**Direen Extended Family, AL-18-005**

Please accept the following comments from El Paso County Public Health regarding the expired variance of use referenced above:

IMPROVEMENT LOCATION CERTIFICATE  
 (If is not a property survey)  
**Landmark Land Surveyors Ltd**  
 (A division of C. A. Jacobsen Engineering Ltd.)

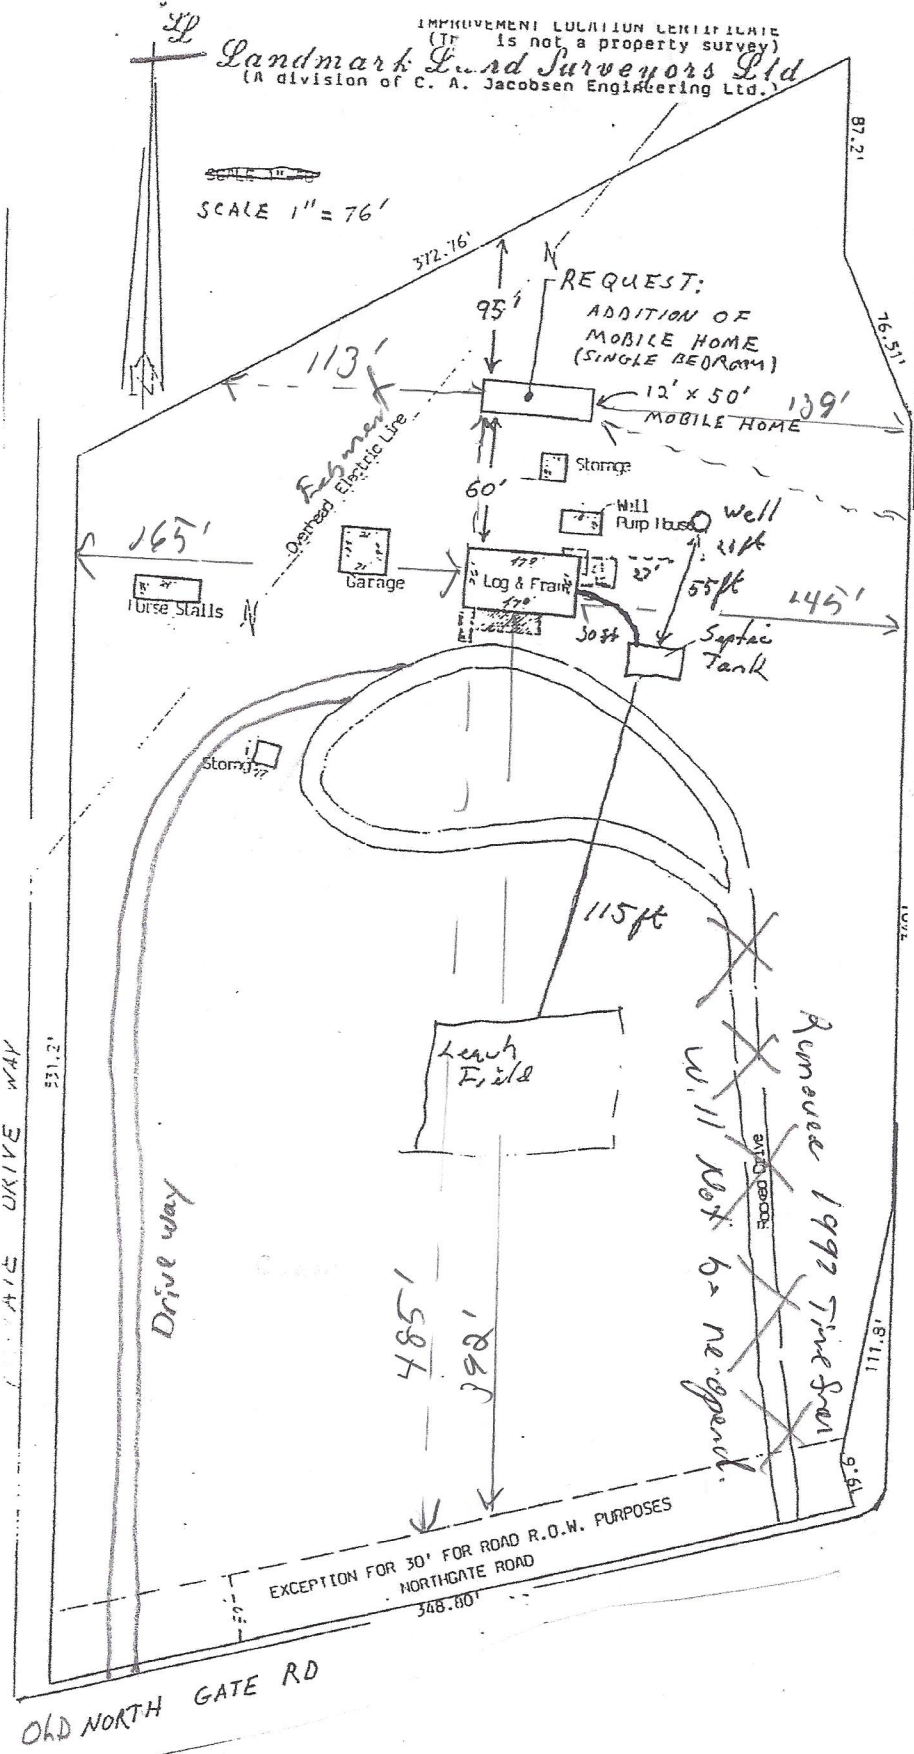
- **Water service for the existing home and the proposed 1-bedroom mobile home is by an individual well.**
- **Wastewater service for the project is provided by an existing onsite wastewater treatment system (OWTS) that was installed in 1991 and sized and approved for a 3 bedroom house. There is no information on file at El Paso County Public Health regarding the connection of the 1-bedroom mobile home to the existing OWTS. El Paso County Public Health requests any information regarding wastewater treatment associated with the 1-bedroom mobile home be submitted for review.**
- **An OWTS Minor Repair Permit may be required if the installation of the building sewer line connection from the 1 -bedroom mobile home is connected to the existing septic tank.**
